CITY OF ALBUQUERQUE

May 28, 2024

**Re: Hope Christian High School
Neighborhood Impact Analysis
Engineer's Stamp 5-15-24 (D18D009)**

TRAFFIC  
CIRCULATION  
LAYOUT

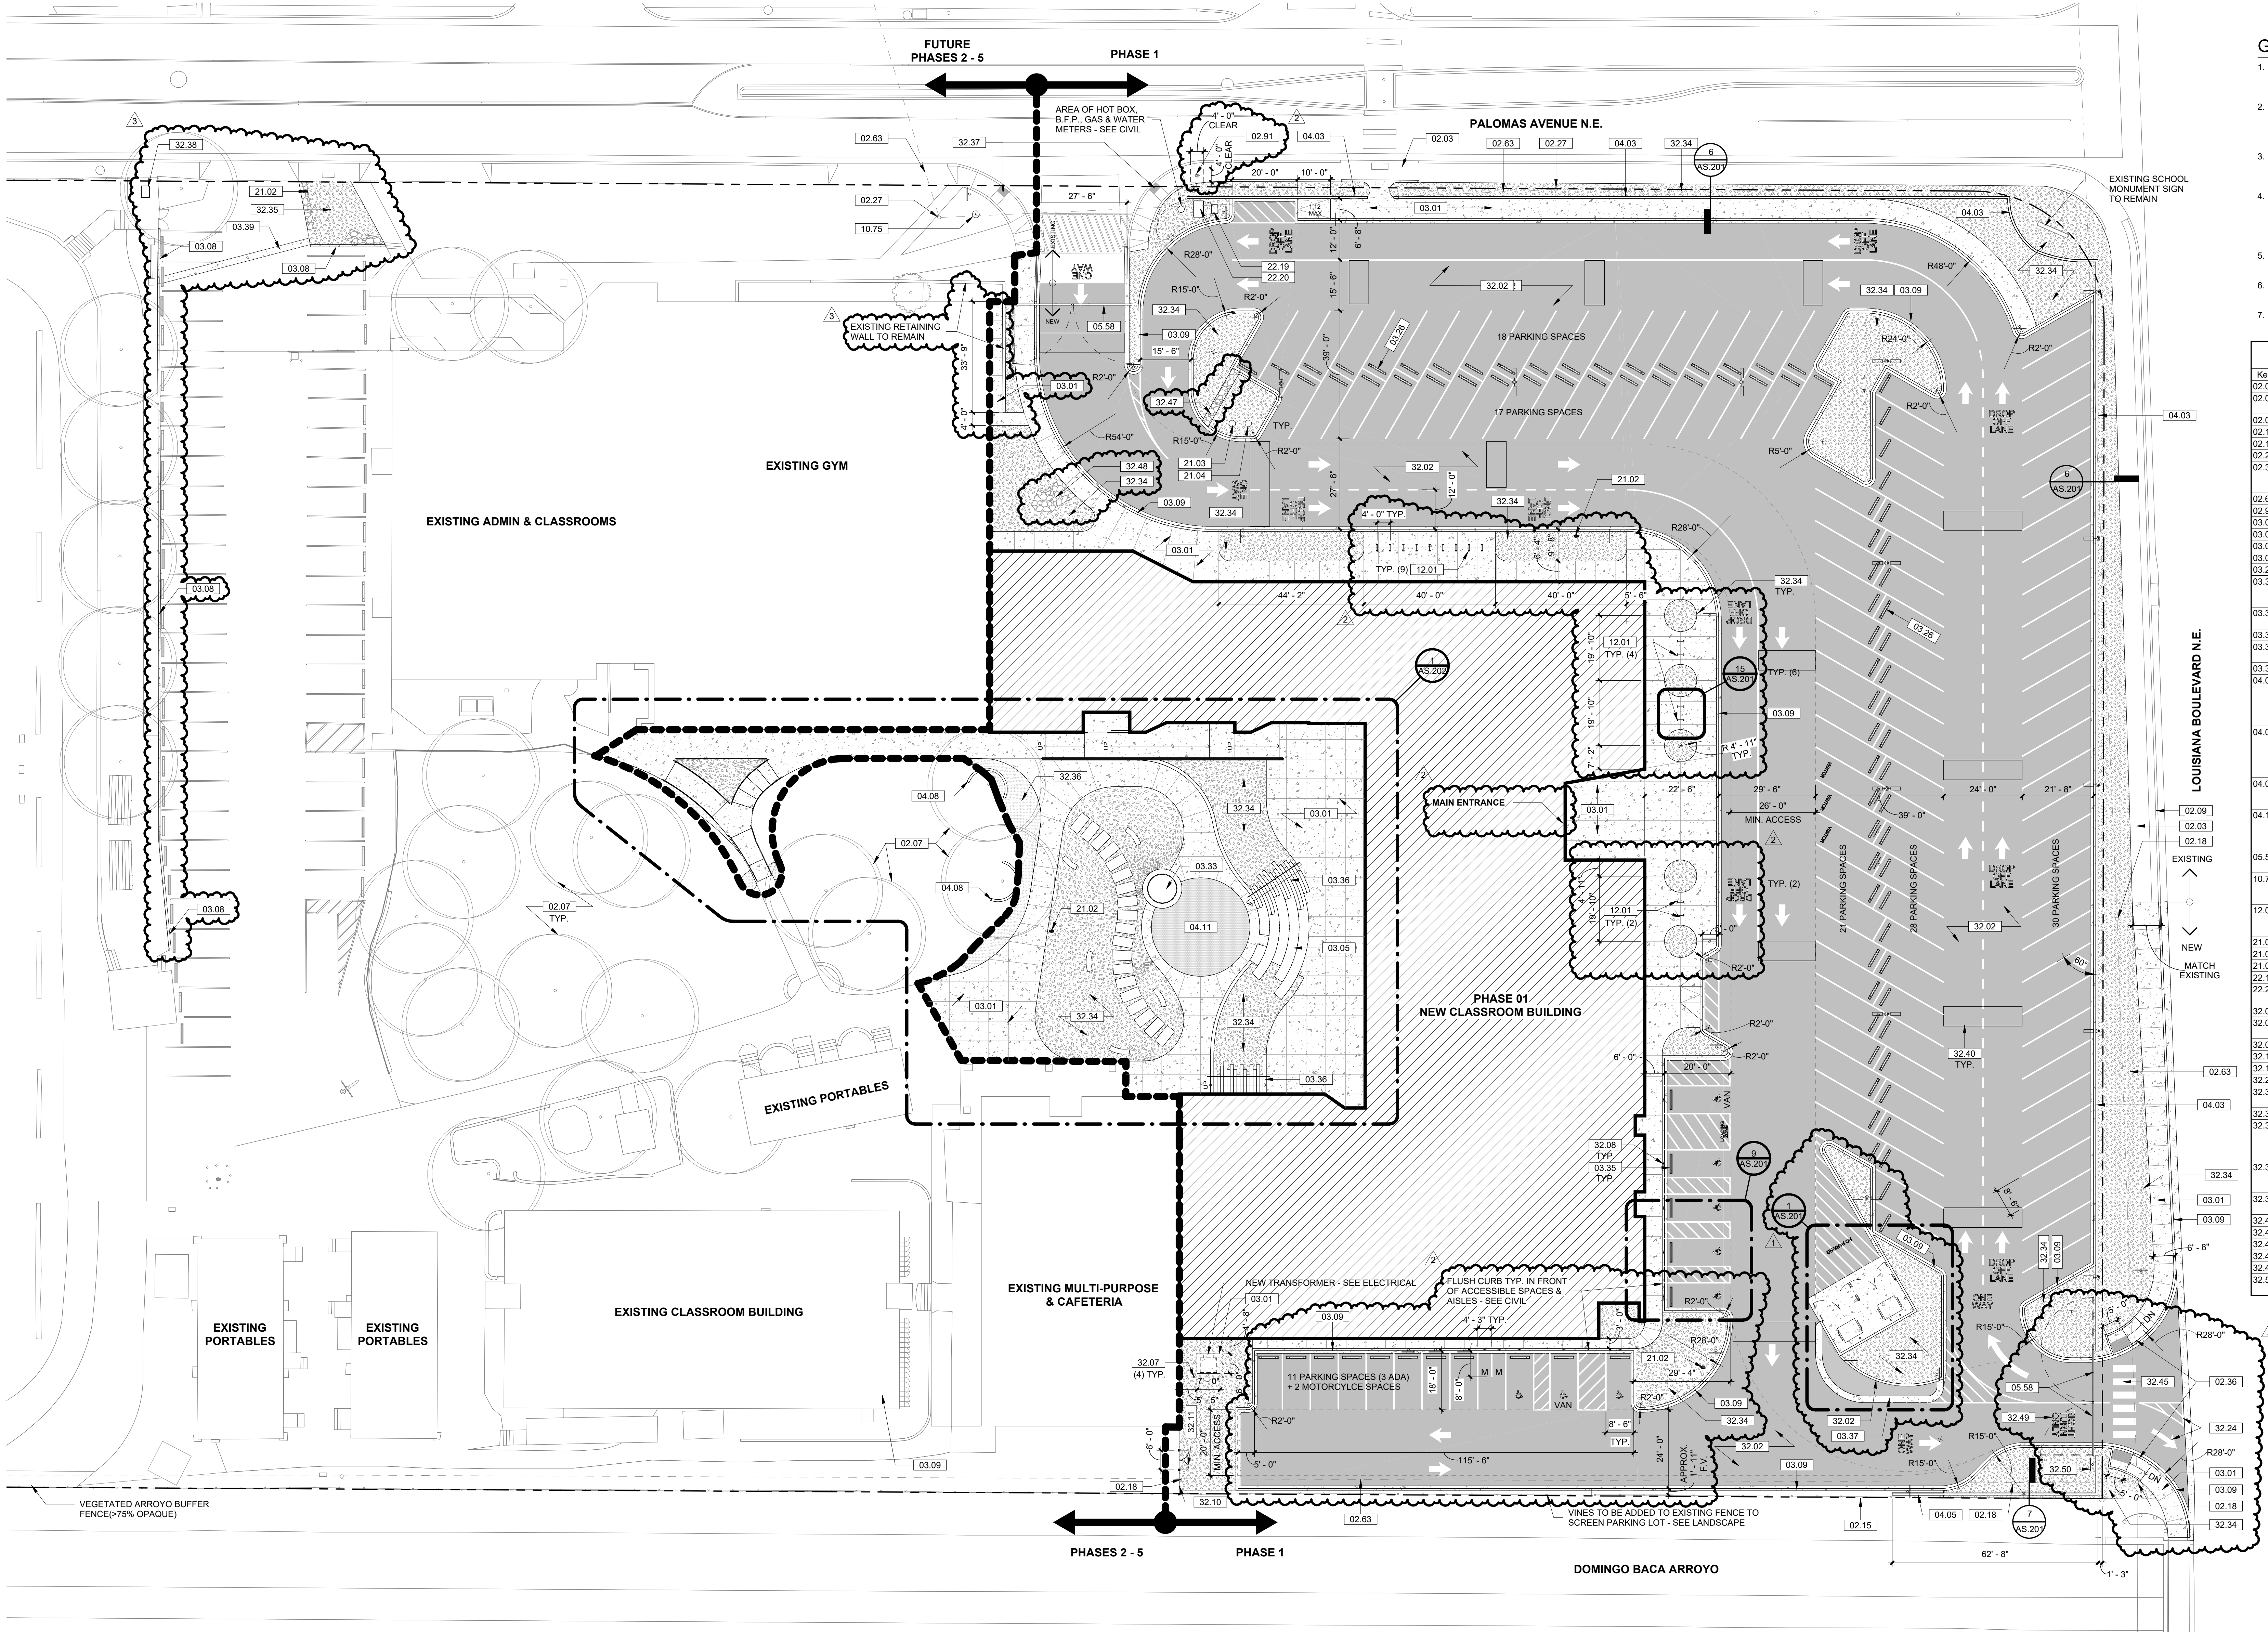
1. Revise the striping of the northbound two-way left-turn lane on Louisiana Blvd approaching the proposed Hope Christian School south driveway to a left-turn lane. Adjust the southbound left-turn lane striping at the access to the FAA facility on the east side of Louisiana Blvd, across from the proposed Hope Christian School access.
2. Convert the two-existing crosswalk on Palomas Ave. to Raised Crosswalks/Speed tables to improve pedestrian safety.
3. Properly sign and mark school zones on Palomas Ave., per MUTCD standards., in coordination with the City.
4. In areas of Palomas Ave. where there are raised medians and curb extensions; on-street parking is prohibited. Use pavement marking words (No Parking) or crosshatching in the no parking zone in addition to the painted curbs and parking restriction signs. .
